Offshore Wind Farms

EAST ANGLIA ONE NORTH

EAST ANGLIA TWO

Issue Specific Hearings 14 (ISHs14)

East Anglia ONE North and East Anglia TWO
Hundred River and Statutory Designated Sites Location

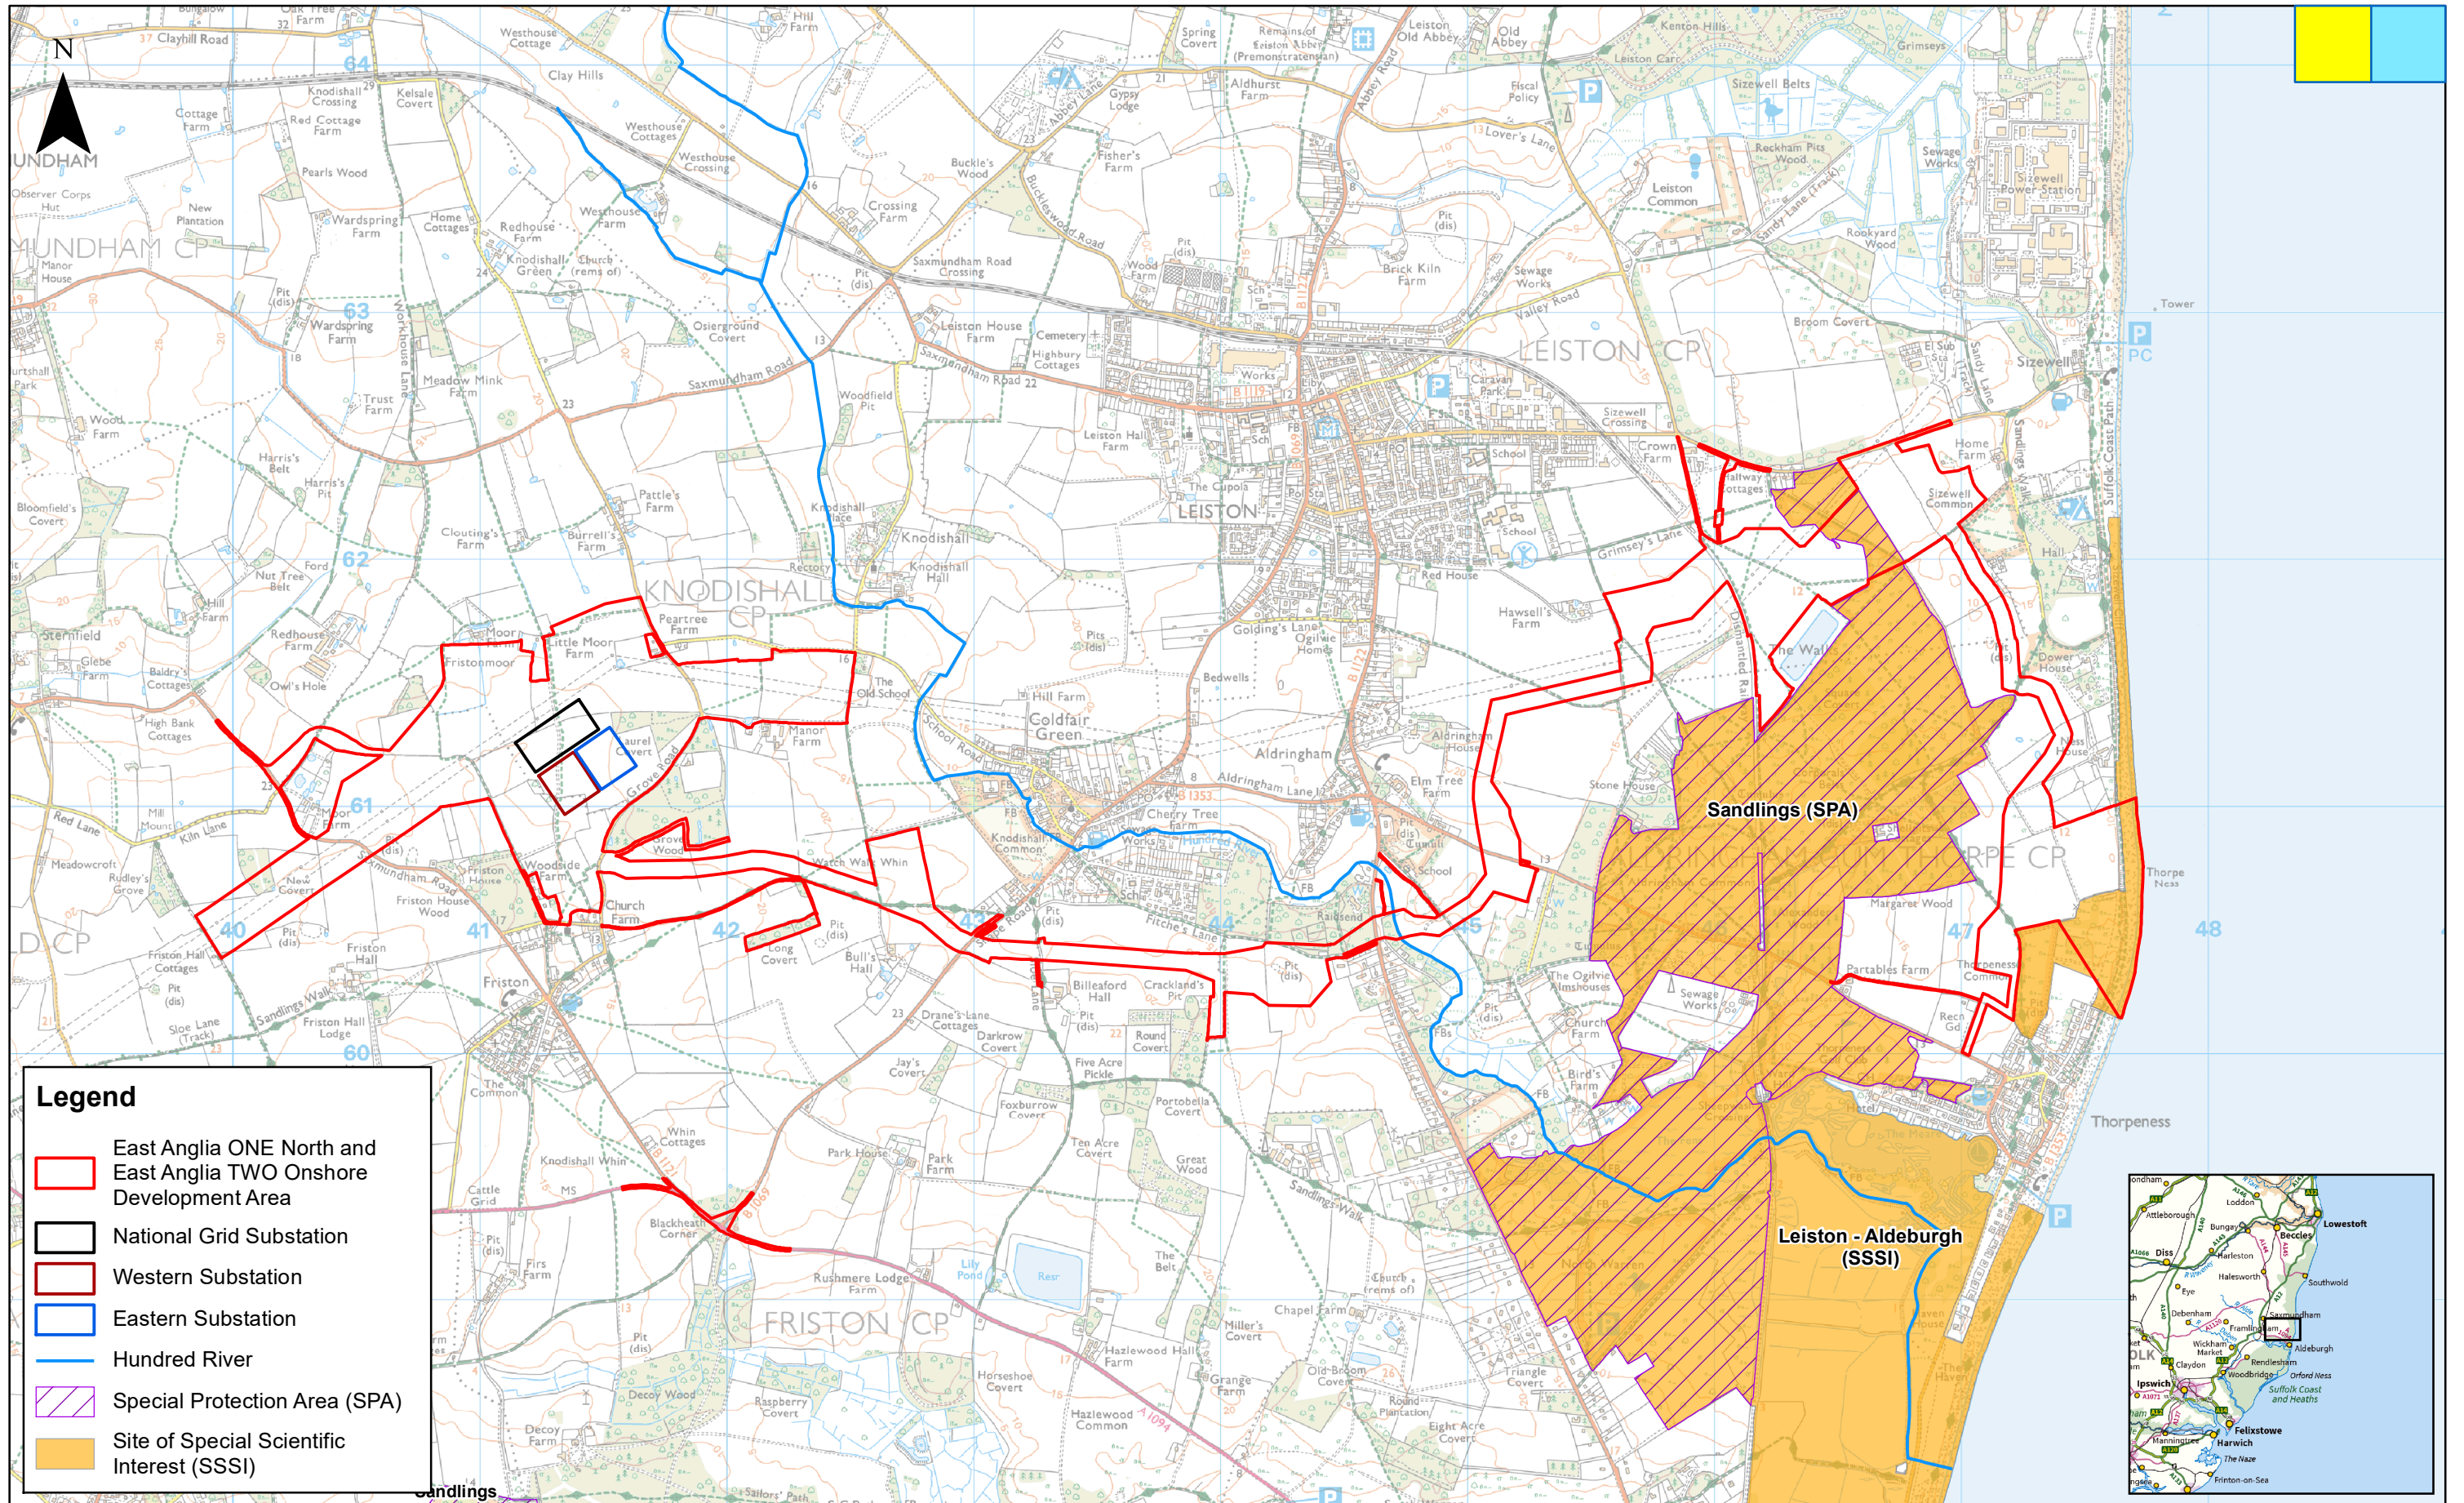
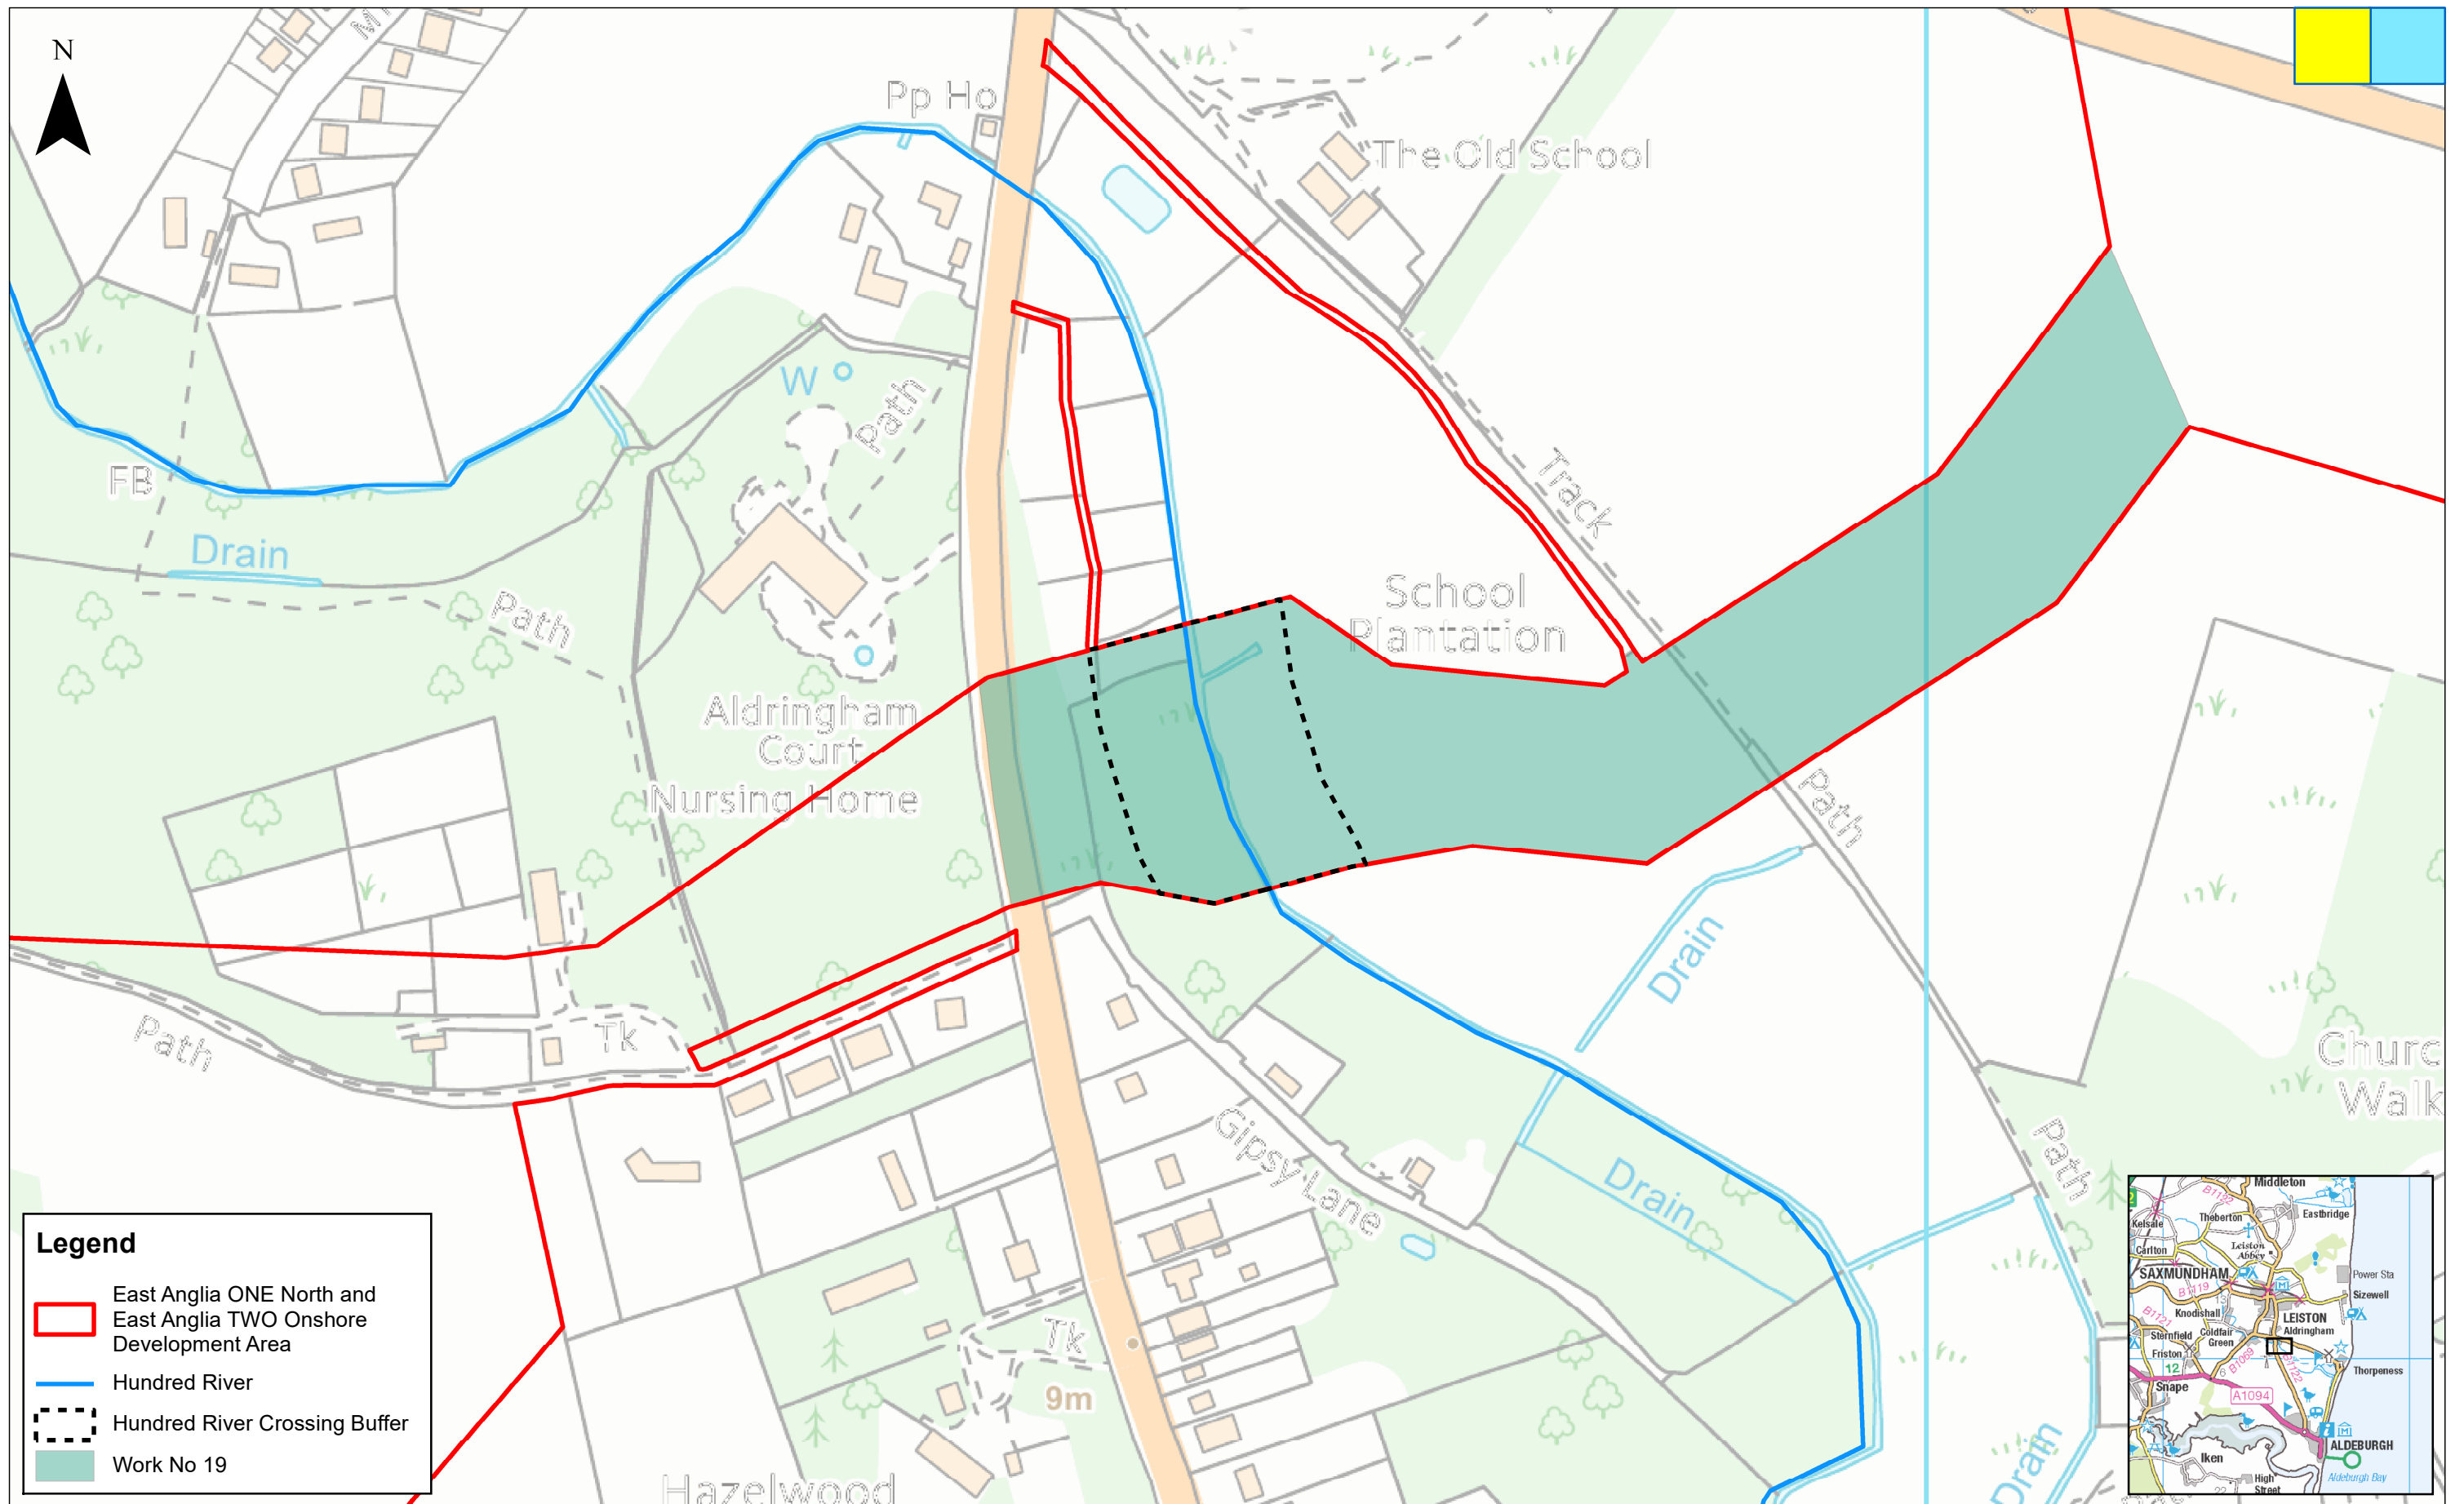
2 DEFRA's mapping of Impact Risk Zones in relation to statutory protected areas confirms that the cable corridor outside the SPA/SSSI will impact unfavourably on the formally protected areas. Work on the River Hundred will impact the SSSI in two main areas: within 600 m of SSSI area 6 to the East and within 1000m of SSSI areas 12 and 13 to the South. The work also impacts the Lapwing Conservation Area to the South East of the crossing point.

3 The River impacts the SSSI by its flow to the South, and also by its catches and ditches, which spread river water west and east, thereby enabling spread by penetration of any likely significant and adverse effects.

4 River Hundred is in itself vulnerable to any indirect and in-combination effects within ex-situ habitats of the SSSI from air pollution/geology/contamination/groundwater/hydrology effects — and is therefore also vulnerable to contributing to LSEs and AEOIs. No proper mitigation is proposed for this aquatic environment.

7 b In other wind farm applications, a number of measures have been proposed to avoid such likely significant events, including trenchless crossings to avoid LSEs for the river environment and SSSI .
